****** FIELD CHANGE LETTER ******

PROJECT #: 21-3366.1-A (Lot 134)

LOCATION: Lot 134, Duncan's Creek

PLANS REF: Smithfield Plan (English Country, Garage Left) Project #: 21-3366 (sealed 8-30-24)

**OPT. KITCHEN W/ EXTENDED CAFE**

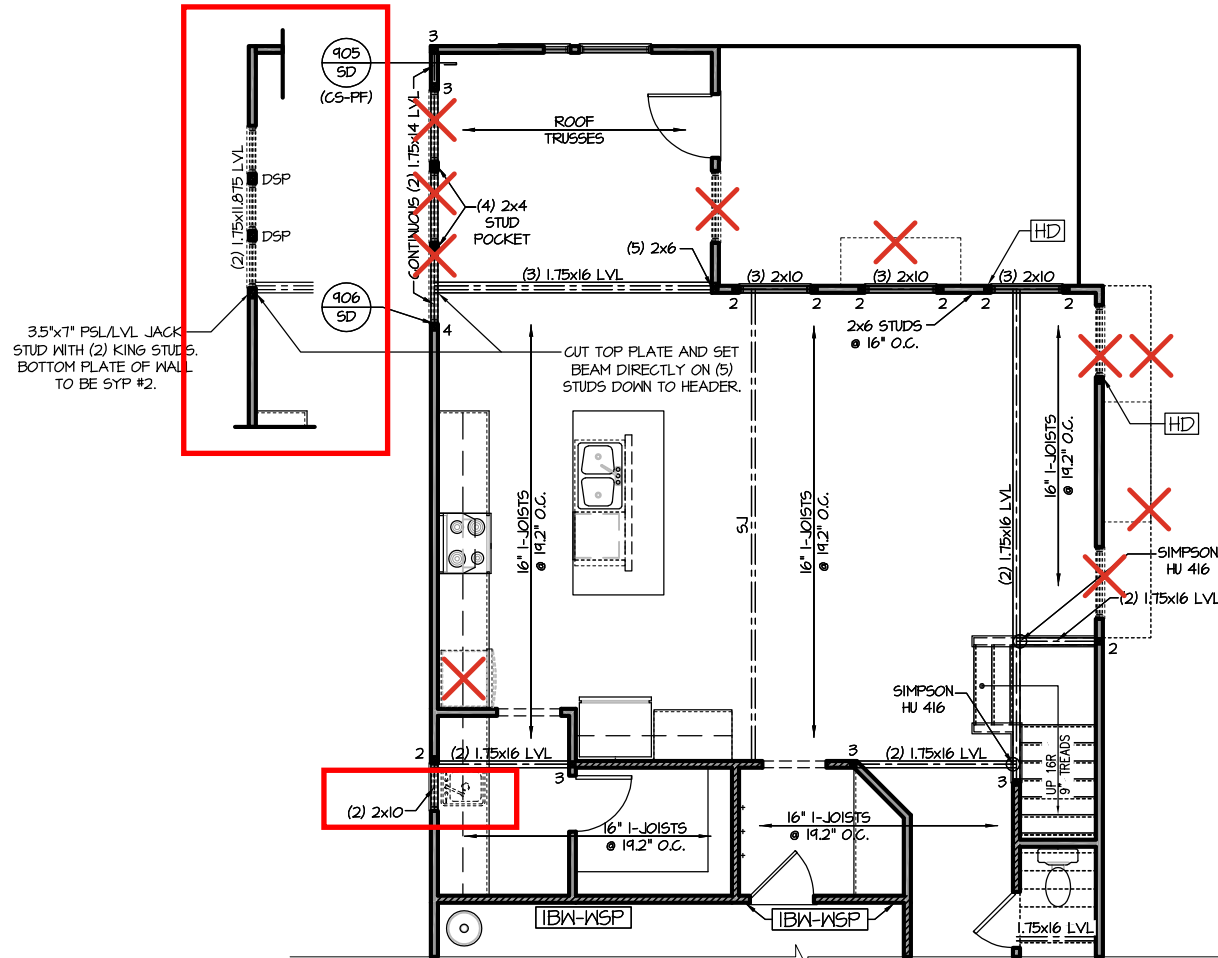
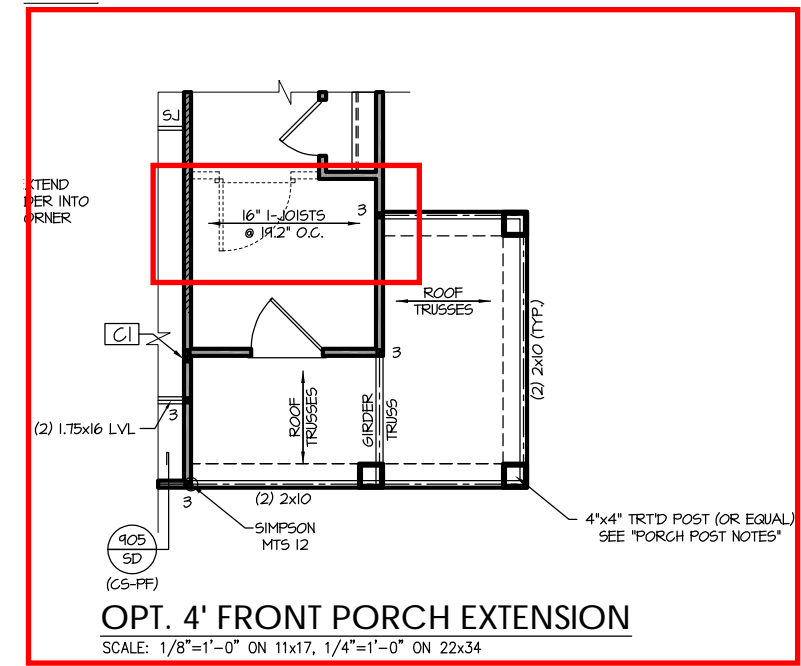
Family Room Wall with Extended Café with Pull-Down Stair Attic: Sheets S-2.1.1 of the plans shows a (3)1.75x16 LVL beam spanning between the Kitchen and the Café. The beam is shown to be supported at the right end by (5)2x6 studs with a 2x6 wall along the rear of the Family Room. (3)2x10 headers with (2) jack studs at each end are shown at the window openings. Based on information provided to Southern Engineers, the rear wall of the Family Room was framed with 2x4 studs @ 12" O.C. (2)2x10 headers with (2) jack studs at each end were installed at each window. The right end of the (3)1.75x16 LVL was supported by a column of (2)2x6 and (3)2x4 studs.

Response: Please note that the above described framing at the rear wall of the Family Room will be structurally acceptable provided that the right end of the (3)1.75x16 LVL is supported on a 3.5"x7" PSL or Glulam column instead of the existing column. The (3)1.75x16 LVL shall be supported directly on the end of the PSL or Glulam column per detail 206B/SD shown on sheet two of this letter.
